DRB Application No.: 05DRB-01133 (P&F) Project # 1004281  
Project Name: RIVERVIEW SUBDIVISION  
Agent: Mark Goodwin & Associates Phone No.: 828-2200

Project Name: RIVERVIEW SUBDIVISION

**CITY OF ALBUQUERQUE  
PLANNING DEPARTMENT  
July 20, 2005  
DRB Comments**

SCHLEGEL LEWIS ARCHITECTS agent(s) for VENTURA PACIFIC CAPITAL COMPANY request(s) the above action(s) for all or a portion of Tract(s) H-6A7A1, **RIVERVIEW SUBDIVISION**, zoned SU-1 IP, located on GOLF COURSE RD NW, between PASEO DEL NORTE NW and SHELLY ROSE RD NW containing approximately 1 acre(s). [REF: DRB-97-245] (C-12)

**AA Monument Sign - Carl's Jr.** Scale: 3/16"=1'-0"

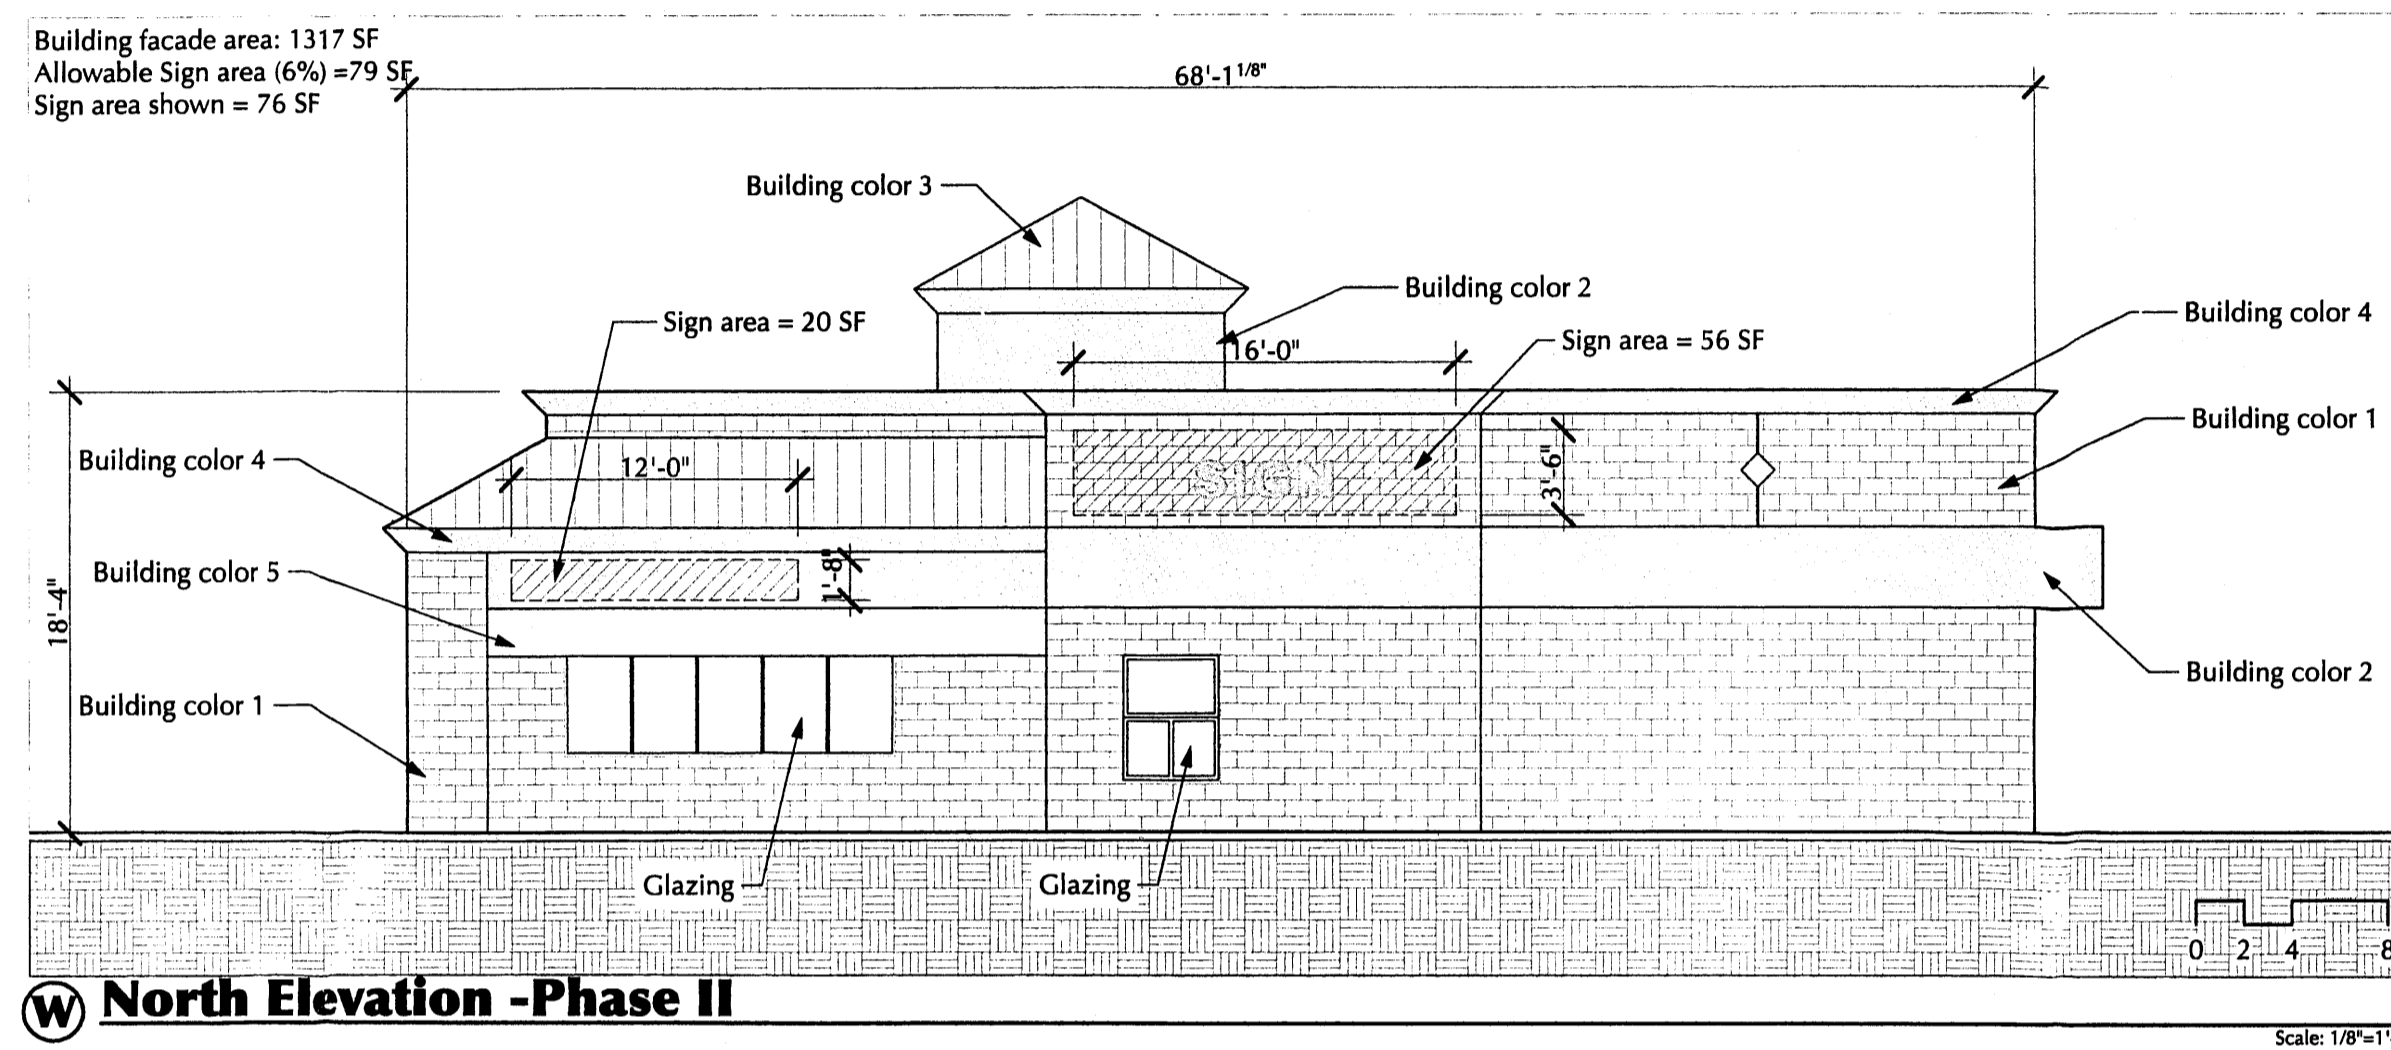
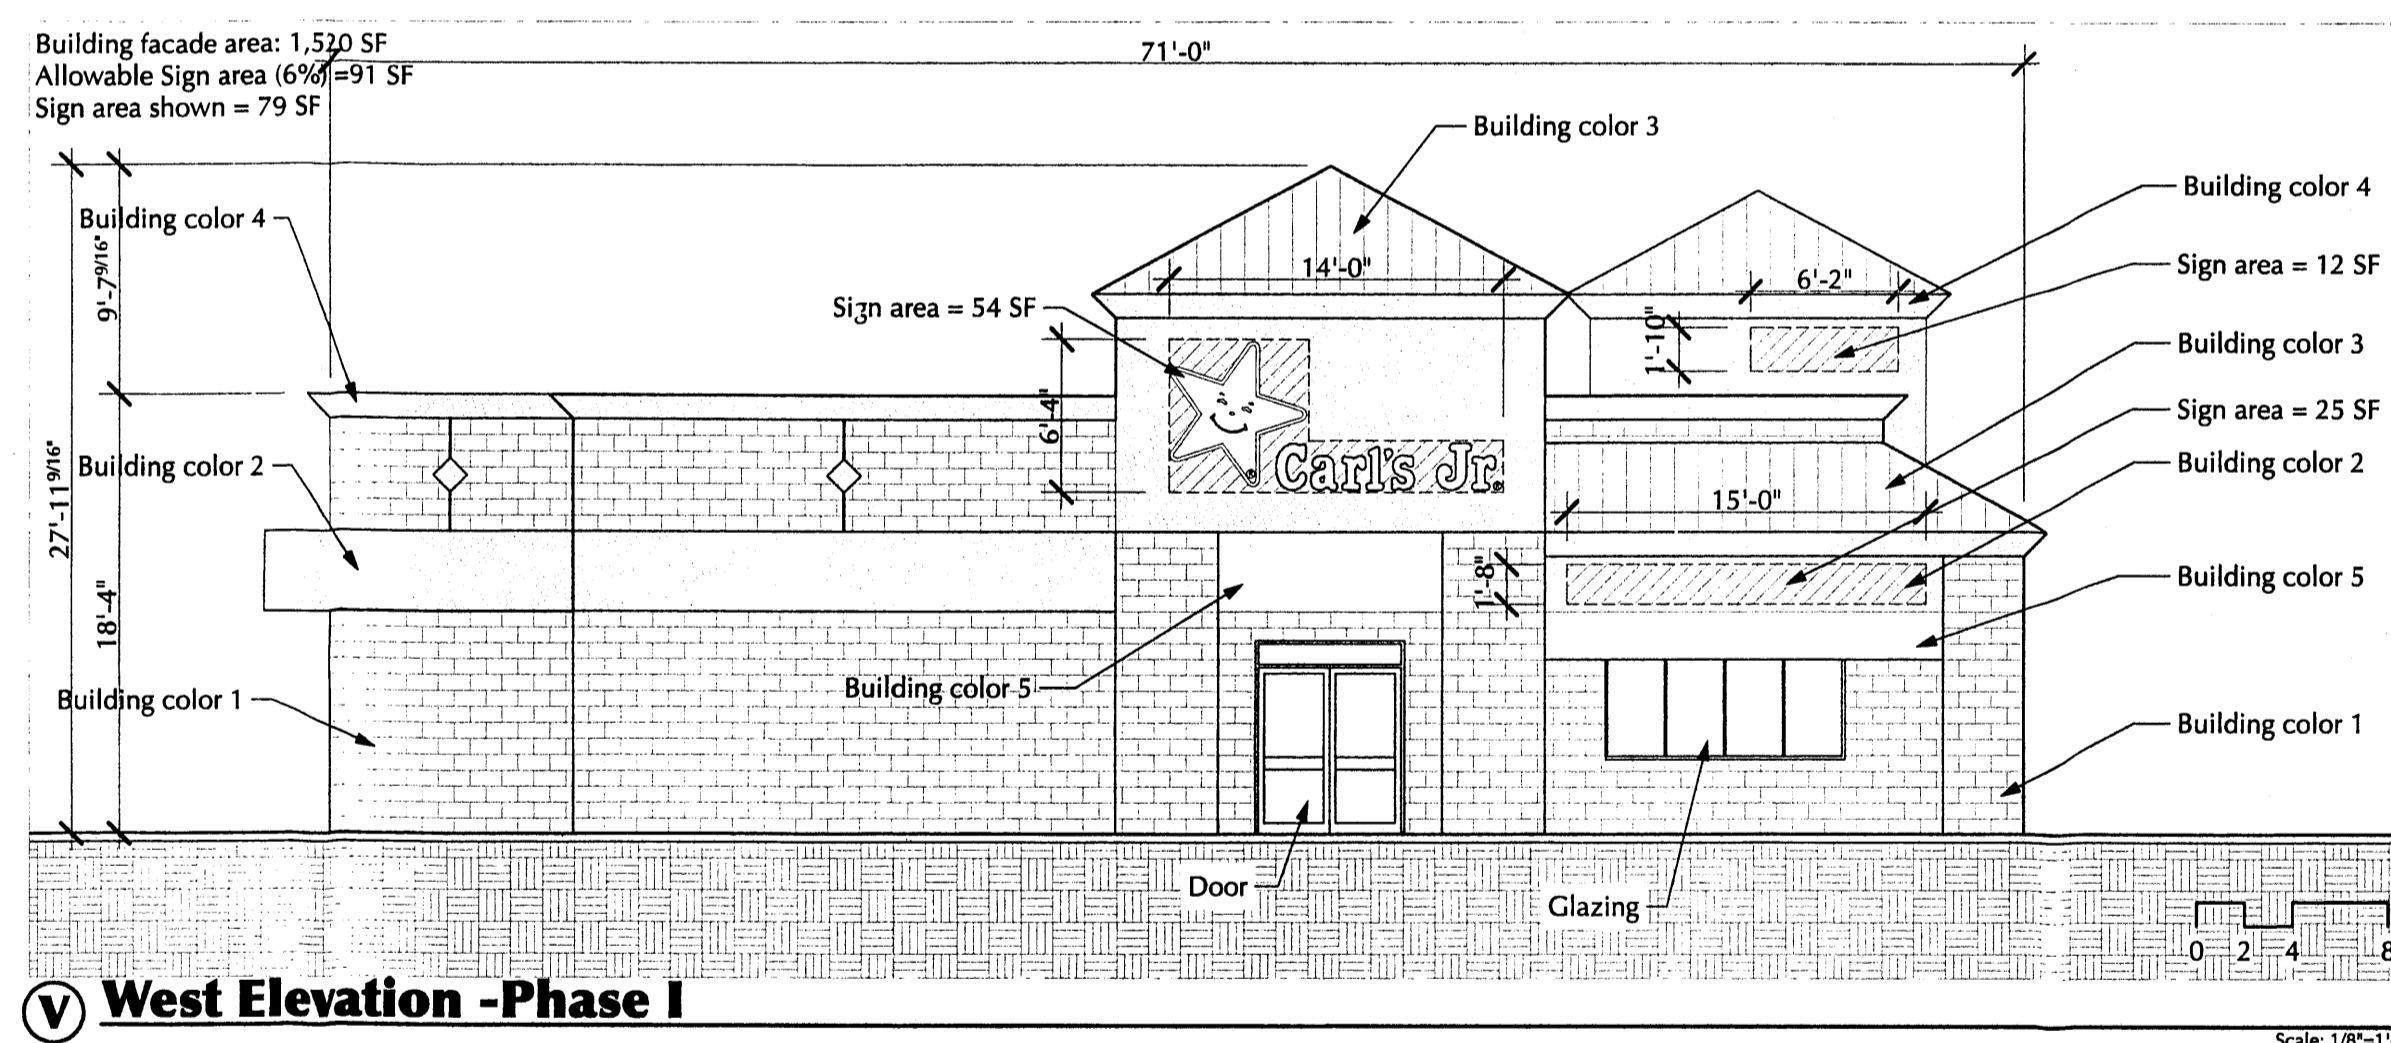
- The square footage of the building mounted signs is required. The colors of monument & building mounted signs are required.
- The Clifford West Business Park Master Plan should be followed with regard to signage. Please provide enough information on the site plan for Planning to make that determination.

PLAT FOR
PARCELS H-6A7A1-A AND H-6A7A1-B
RIVERVIEW PARCELS
 WITHIN THE
 TOWN OF ALAMEDA GRANT
 PROJECTED SECTION 13
 TOWNSHIP 11 NORTH, RANGE 2 EAST, NMPM
 CITY OF ALBUQUERQUE
 BERNALILLO COUNTY, NEW MEXICO
 JUNE, 2005

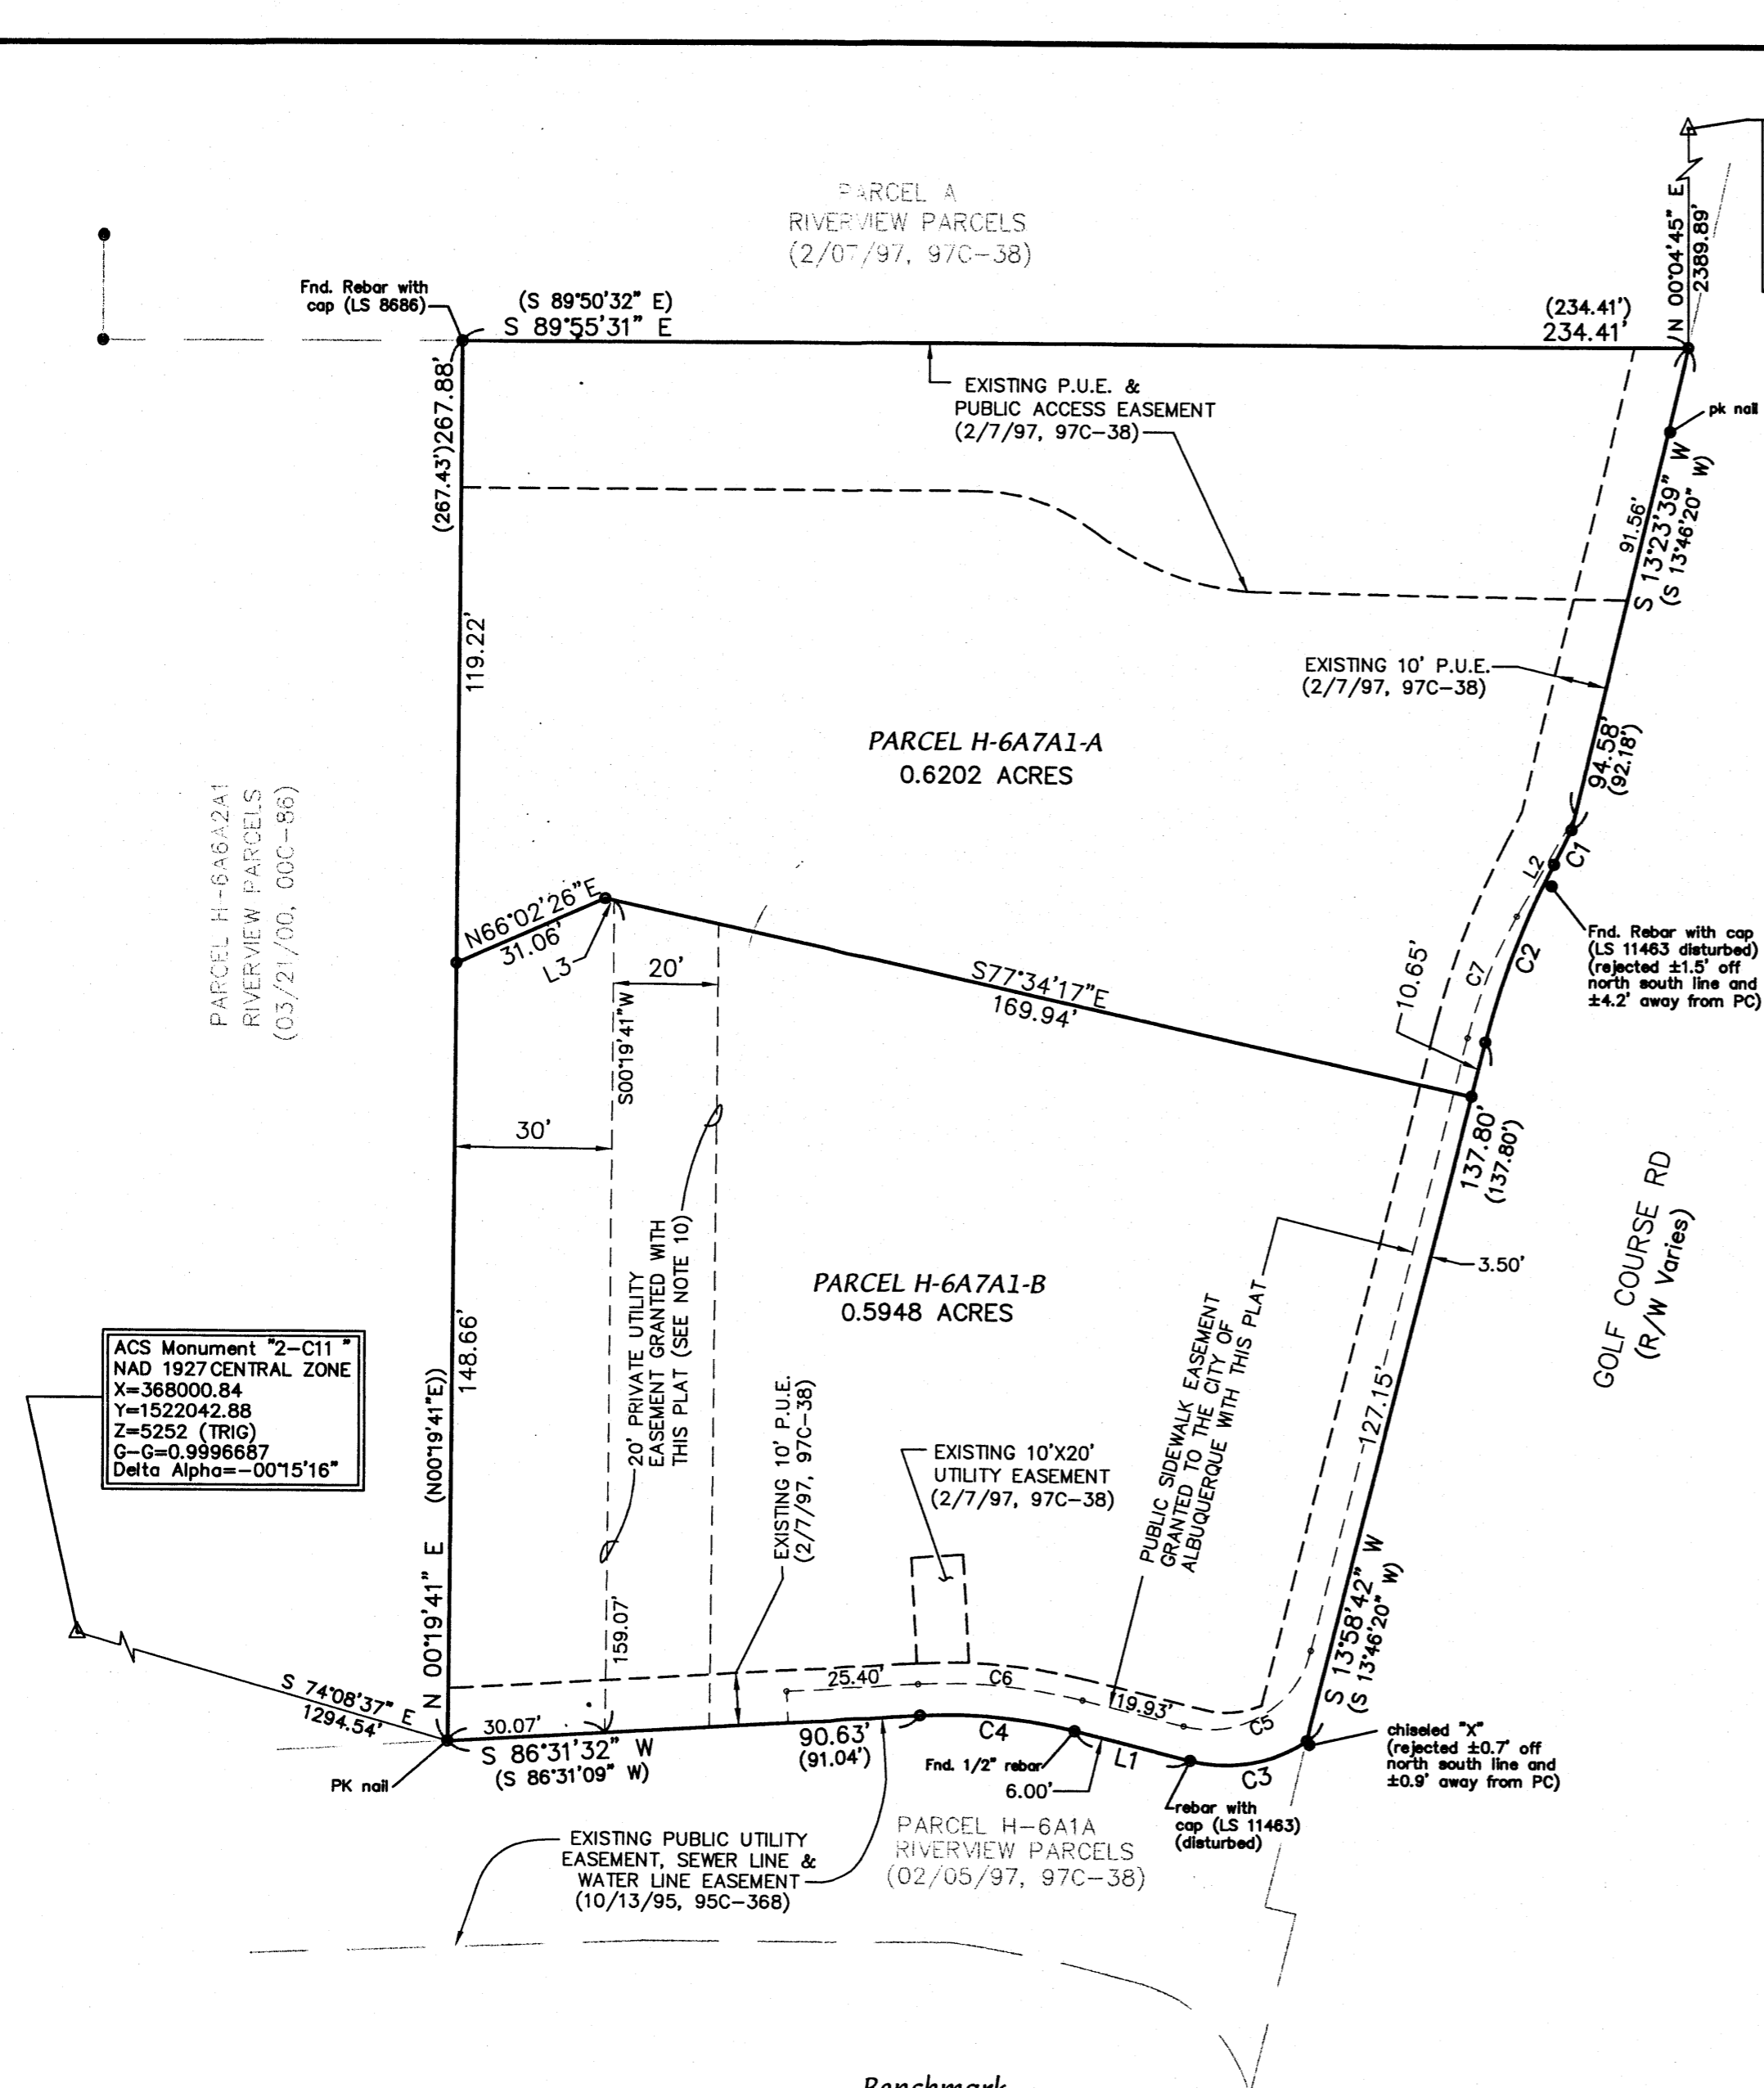
The preliminary and final plat was approved with final plat sign off delegated to Transportation Development for right to use access points and Utilities Development for signatures of New Mexico Utilities Inc., a better description of 10-foot utility easement and provide beneficiary and maintenance statement for easement.
